**WEST SUSSEX COUNTY COUNCIL
STRATEGIC PLANNING CONSULTATION**

SUBJECT: BN/19/16/PL - Demolition of vacant office building & erection of 7 No. dwellings with associated garaging & landscaping. This application is a Departure from the Development Plan.

Land at Pollards Nursery, Lake Lane, Barnham, West Sussex, PO22 0AF

Drawing Title:
General Arrangement Plan

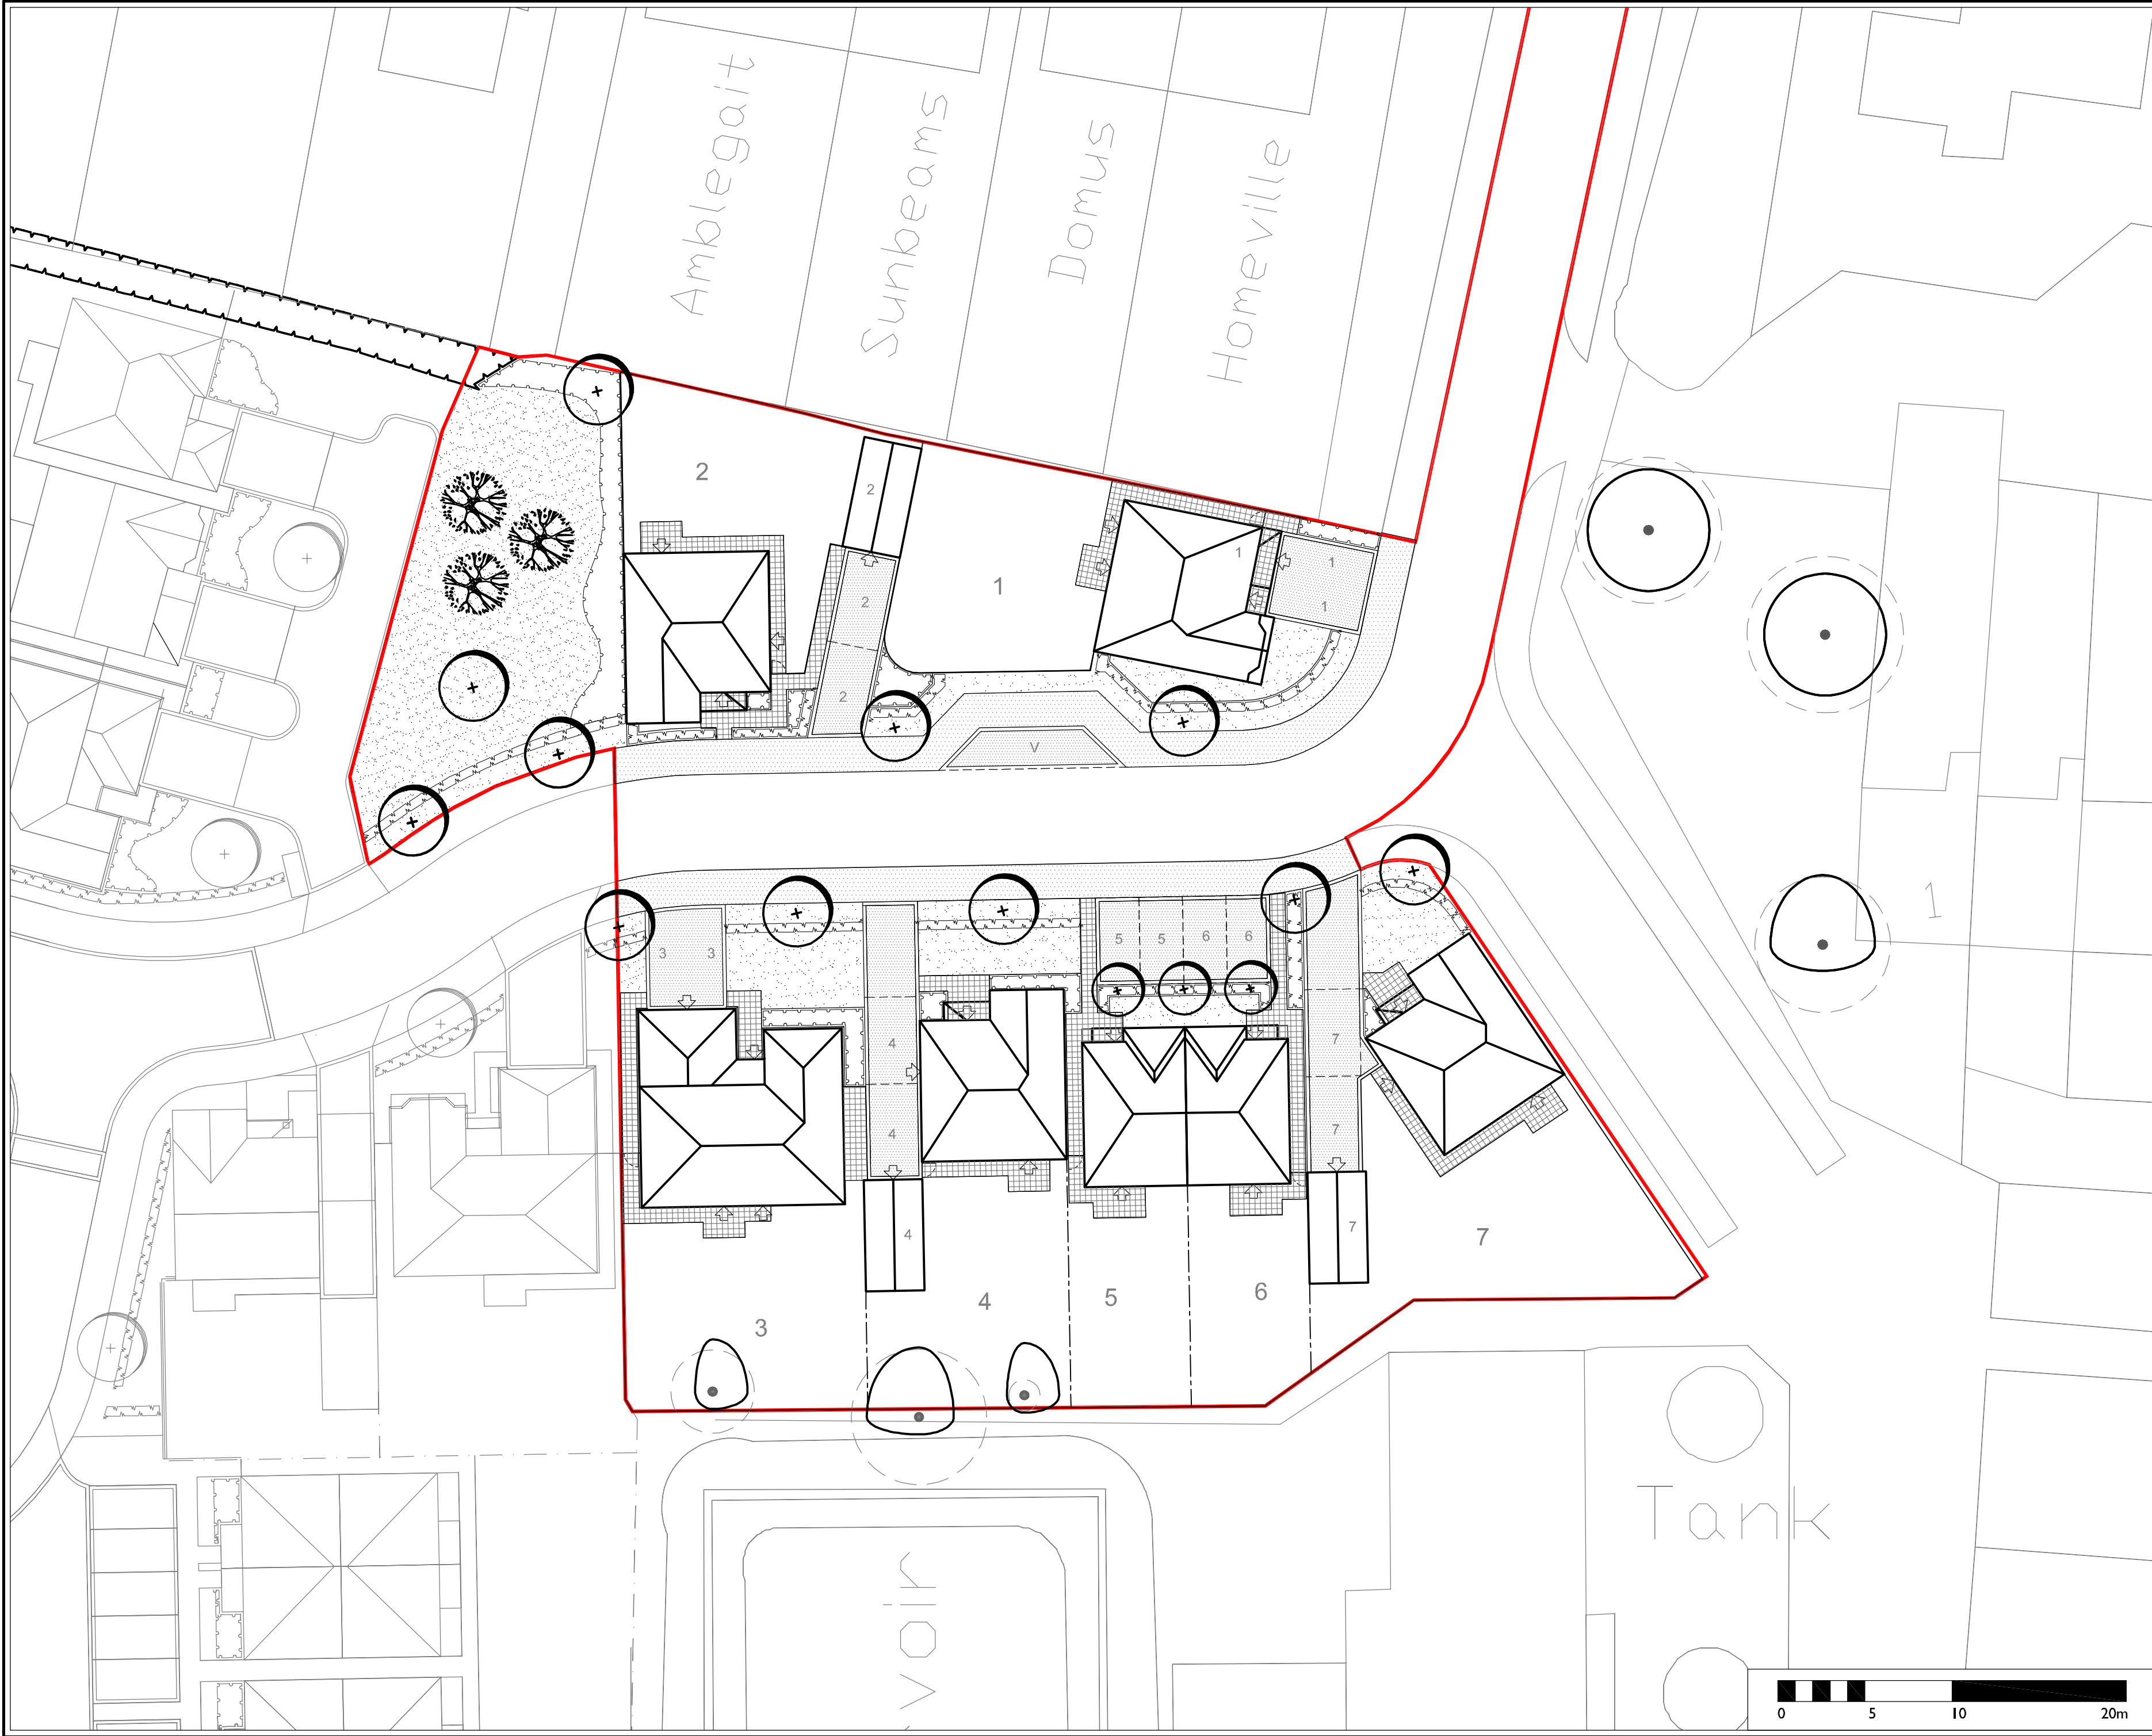
I would note that the width of hardstanding serving plots 1 and 3 do not scale to 4.8 metres, which would be the standard for two standard car parking spaces side by side. I would advise that a slight modification be made to ensure all hardstanding spaces measure 2.4 x 4.8 metres or 4.8 x 4.8 metres for double spaces, I would be satisfied that these modifications could be secured via planning condition. It is also noted that the parking arrangement for plot 2 is a garage space fronted by two tandem hardstanding spaces. In this instance it would be advised the garage door is a roller shutter type door, it is likely that if a up and over door is provided there would be insufficient space to open the door with two cars parked in on the hardstanding without a vehicle protruding onto the proposed footway.
